From: [Haley Mercer](#)
To: [Jeremy Johnston](#)
Subject: RE: Final Plat Review Request LPF-21-00010 Tiger Plat
Date: Monday, October 11, 2021 12:06:41 PM
Attachments: [LPF-21-00010 Tiger Plat Map Small Format.pdf](#)

CDS has received a final plat application, file number LPF-21-00010 Tiger Plat. This application received preliminary approval under file number LP-08-00022. Below is a link to the final plat application submittals which also contains the preliminary approval Resolution (2009-149). The large format plat map was originally submitted in 2010 and partially reviewed at that time. The applicant has been informed that this plat map will require a new surveyor signature/certificate and a new signature from current Public Works Engineer for final approval. He has agreed to provide these following the initial review utilizing the old mylars. Please submit any comments or revision requirements by October 18, 2021 at 5pm. Let me know if you have any issues accessing the documents.

LP-08-00022

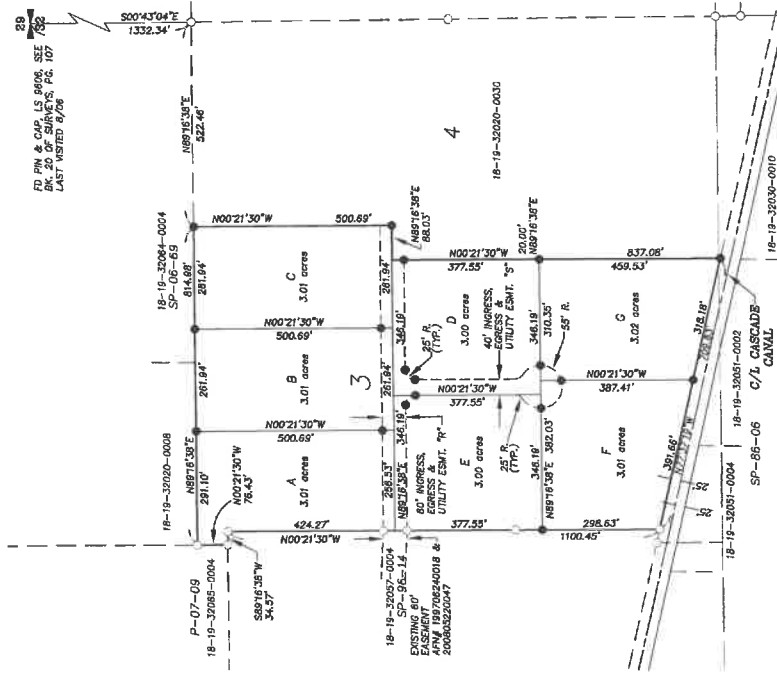
The only thing I can see is on the second page. In the left top corner, were the owner of the parcel is listed is not consistent with what is on TaxSifter.
